CITY OF ALBUQUERQUE

December 4, 2017

**Re: Blue Sky RV Storage
Erosion and Sediment Control Plan
Engineer's Stamp Date 11-29-17 (D16E002A6)**

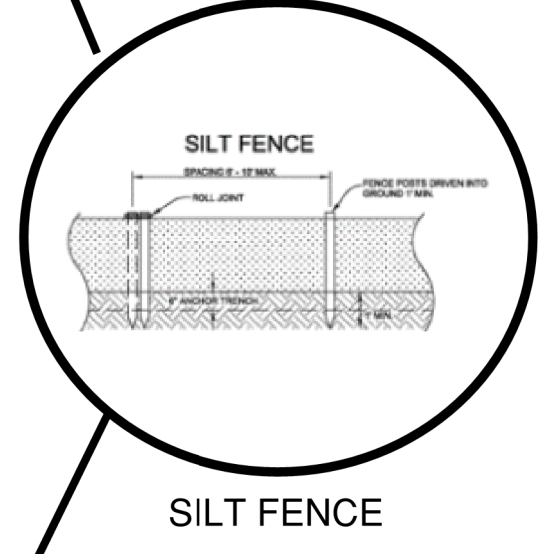
1. The upstream end of the culvert in the southwest corner of the site should be protected and you would need permission from the landowner to the west to place the BMP on their property. It may be better to just protect the upstream end of the culvert.
